**MP11\_0002 (MOD 1) (RESIDENTIAL BUILDINGS R8 & R9) - RESPONSE TO SUBMISSIONS  
BARANGAROO SOUTH**

We write to you on behalf of the proponent Lend Lease, in response to the issues raised in relation to Modification 1 to Residential Buildings R8 & R9 (MP11\_0002) (herein after referred to as Residential Buildings R8 & R9 (Mod 1)).

This response also includes an addendum relating to the following design amendments:

Project	BARANGAROO SOUTH
Title	RETAIL Retail Shopfront Options
Drawn By	CHS
Date	15/04/14
Purpose	SP70W
Approved By	JP
Date	
Scale	SCALE 1:100 @ B1 1:250 @ A3
Site No.	BR8
Drawing No.	BR8AD2000051-00
Revision

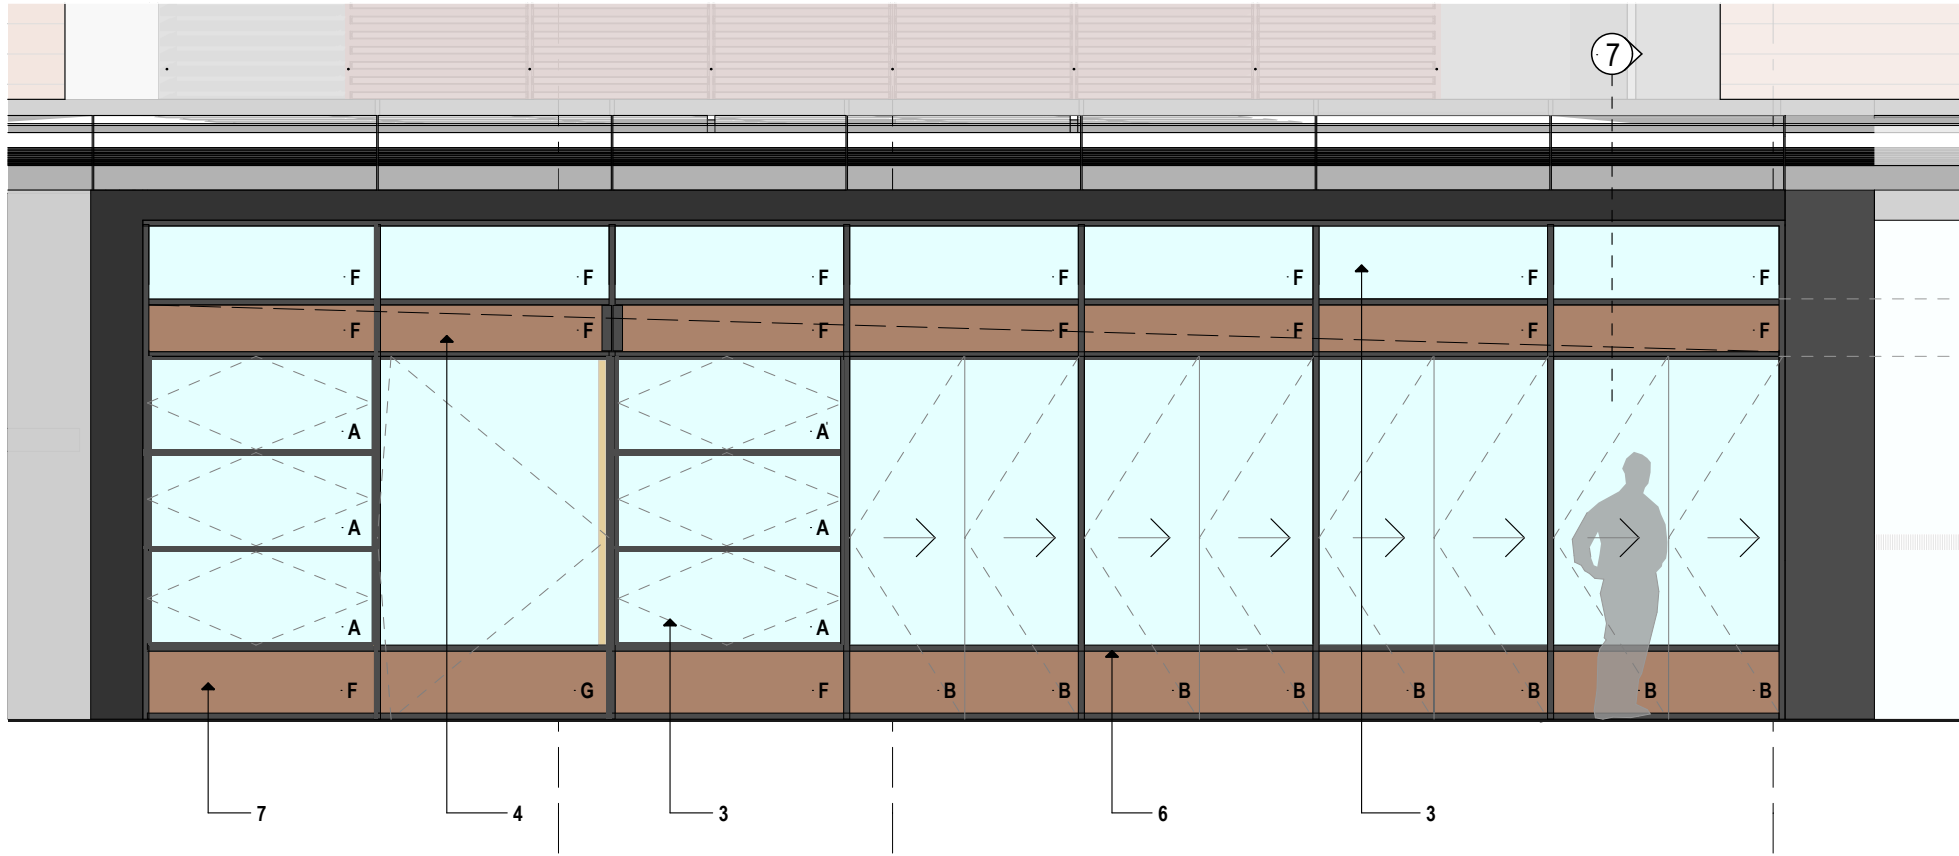
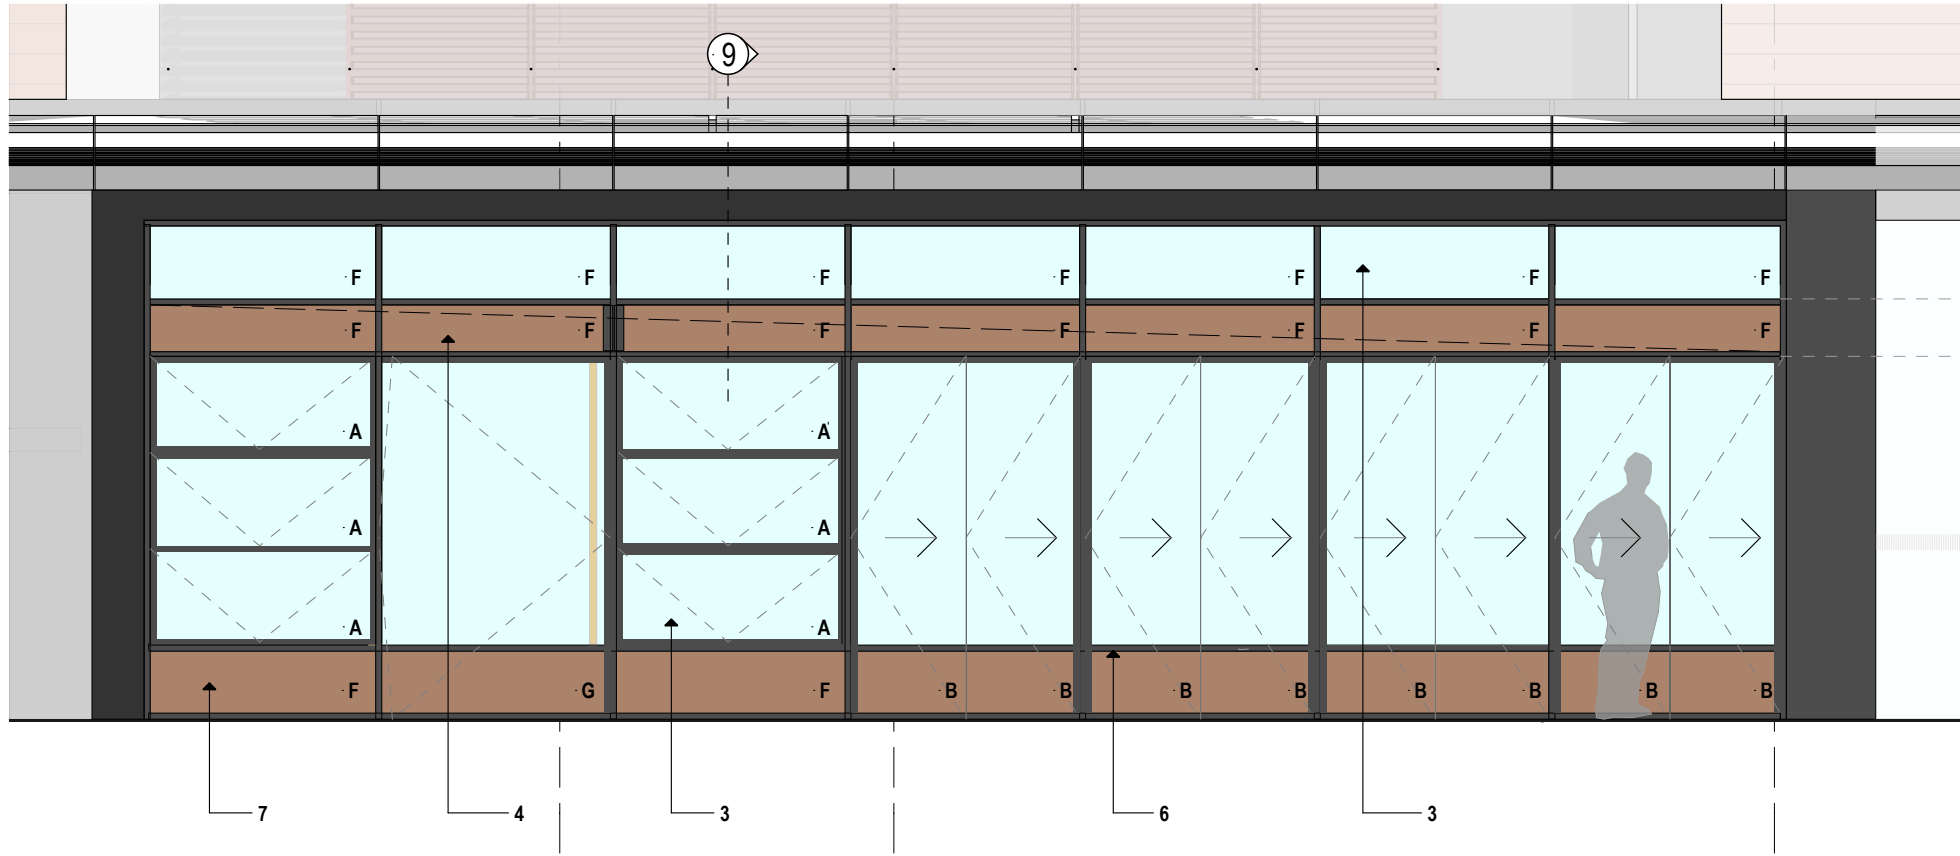
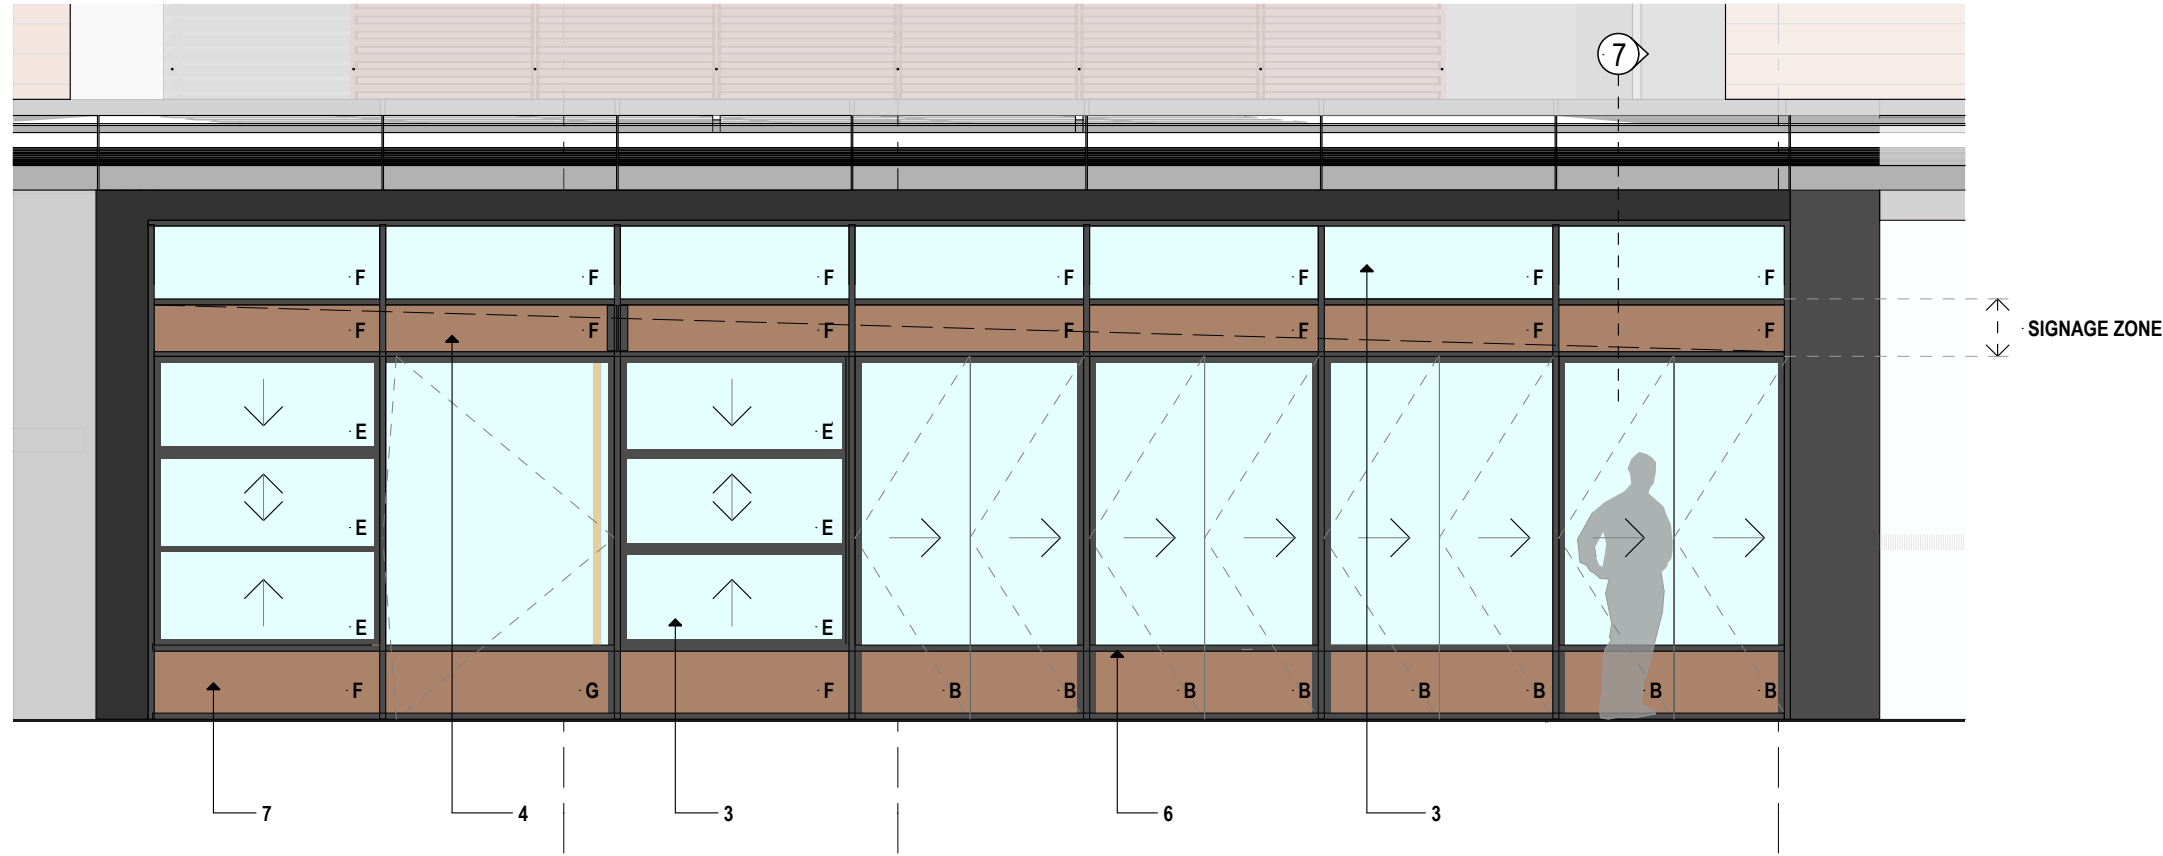
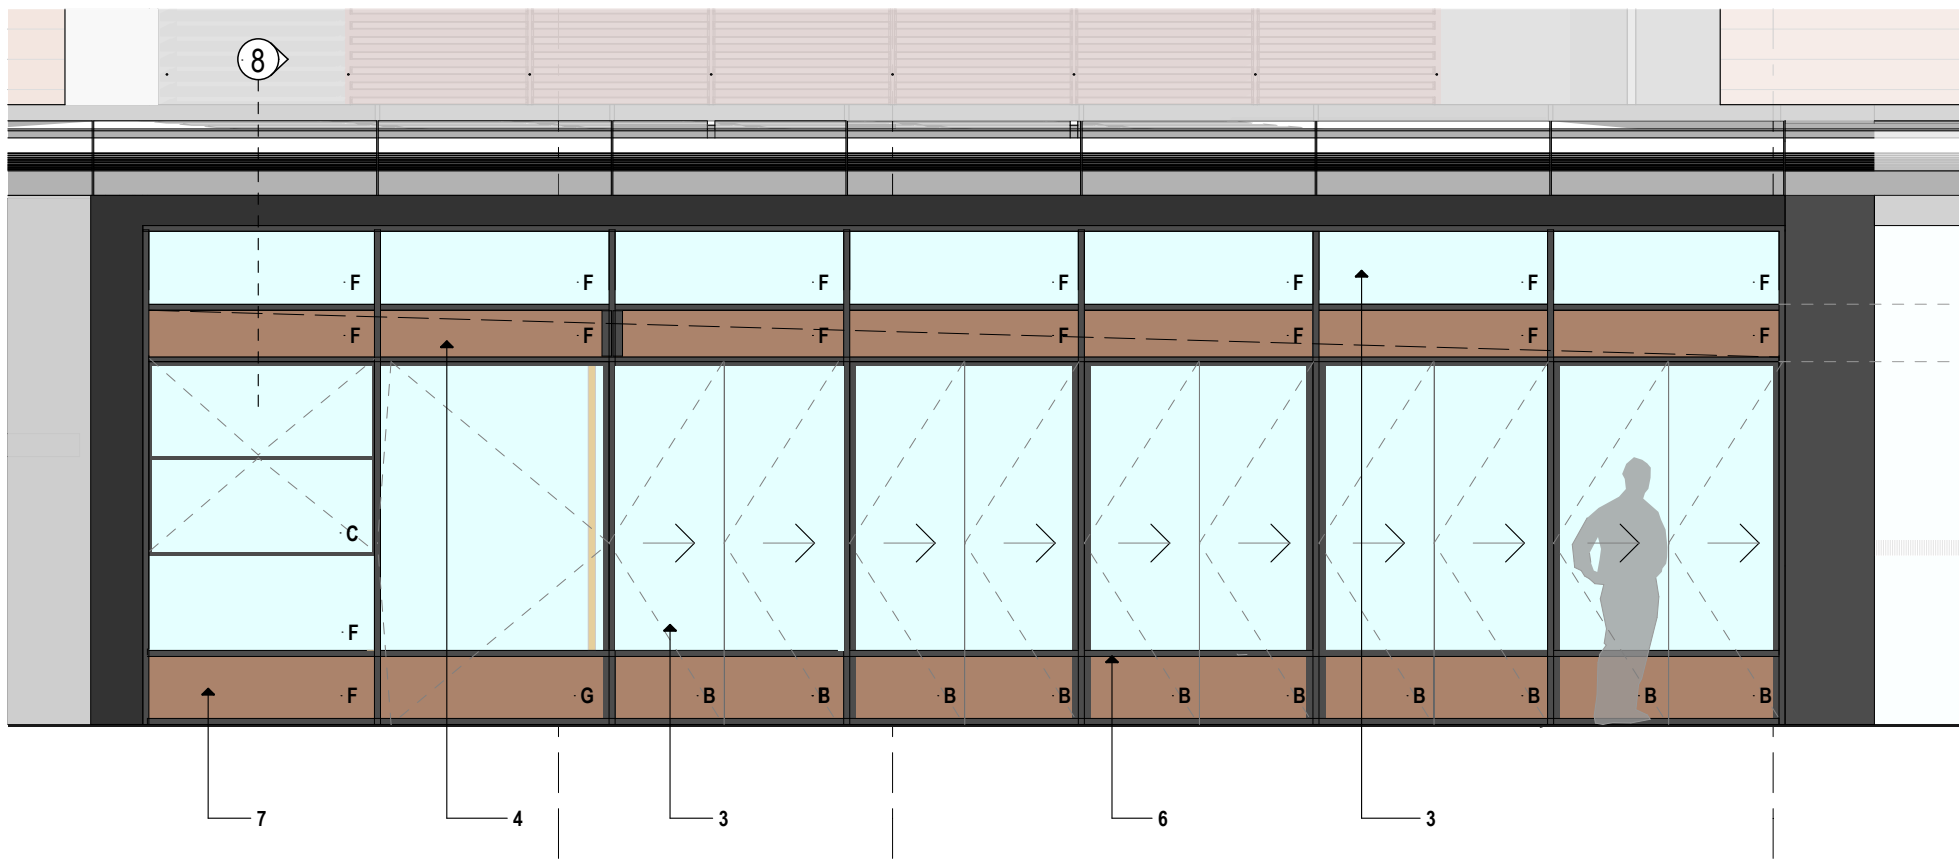
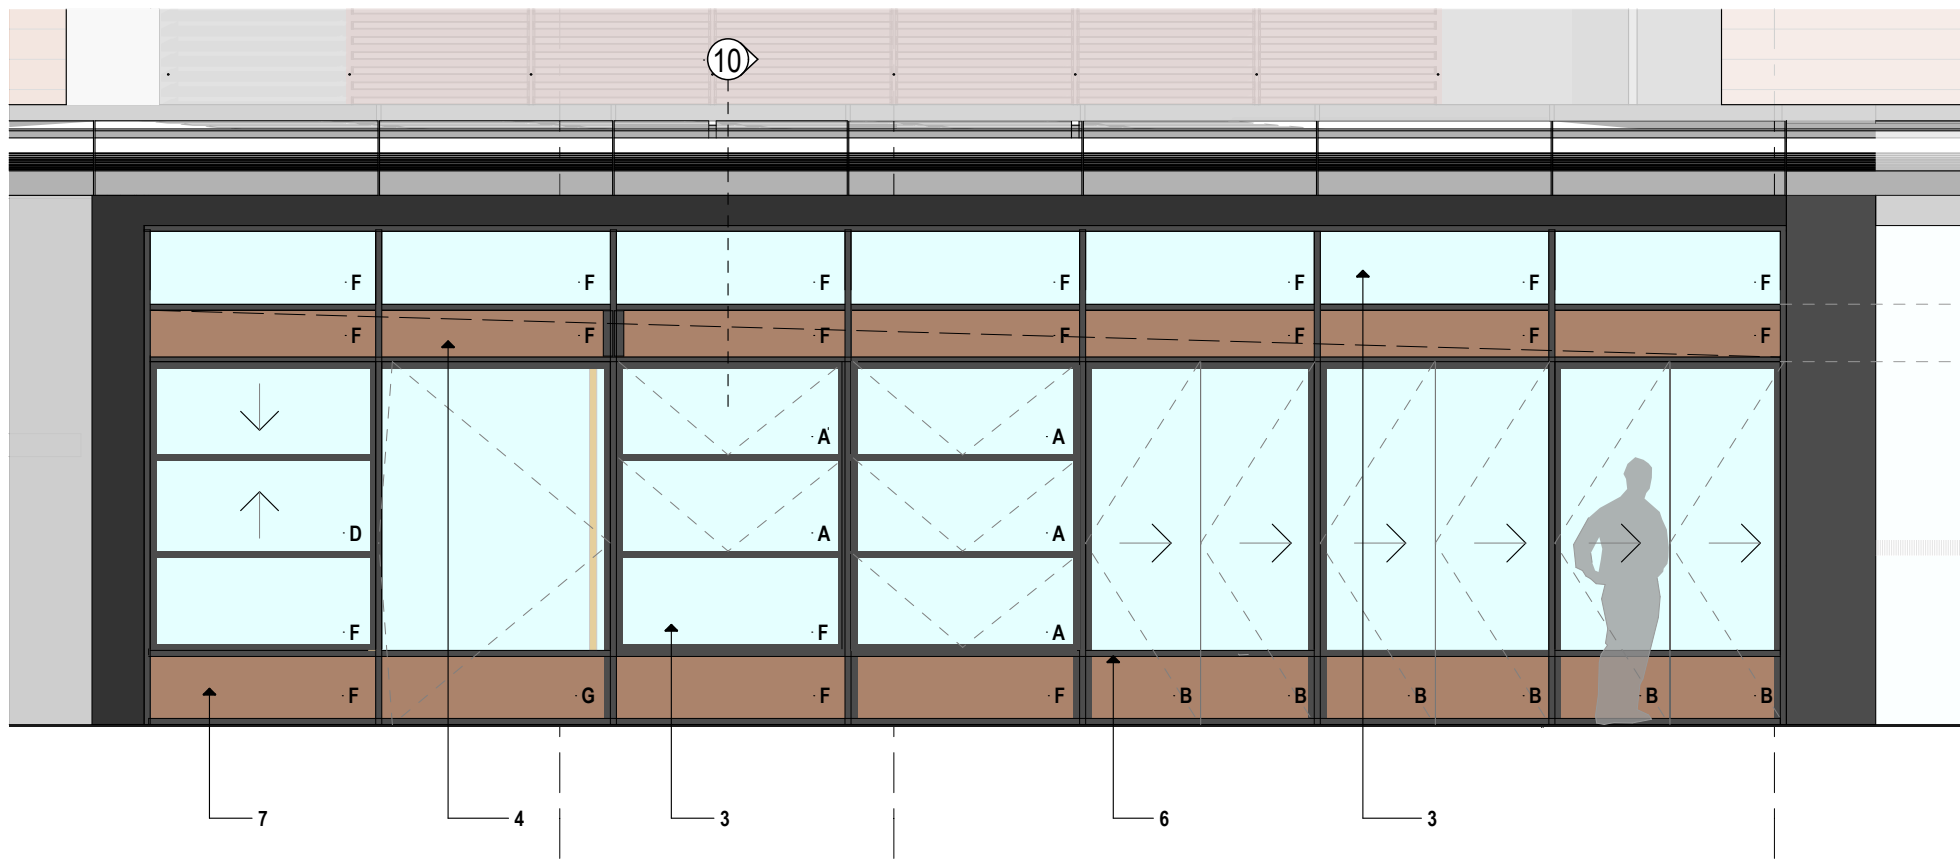
The proposed amendments to the shopfronts on the western, northern and southern façade of Buildings R8 & R9 are indicated on the Architectural Drawings with notations. These notations identify that the detailed design of the shopfronts will either be the subject of design development undertaken by Lend Lease, or the subject of a further approvals by the future tenants, prior to construction. The following design parameters have been included in these notations in order to provide guidance under both scenarios:

- minimum 55% transparency glazing for shopfronts; and
- partially operable shopfronts are permitted.

***Separate approvals are required for the detailed design of shopfronts. The future shopfront designs of Buildings R8 & R9 are to be consistent with the following:***

- ***All works must comply with the Building Code of Australia and relevant Australian Standards;***
- ***Shopfronts may include operable/fixed elements, such as glazing, windows, doors, benches and the like;***
- ***The minimum transparency of the glazing is to be 55%; and***
- ***Signage is to be consistent with the signage strategy, which is to be submitted to the Secretary prior to issue of a relevant construction certificate.***
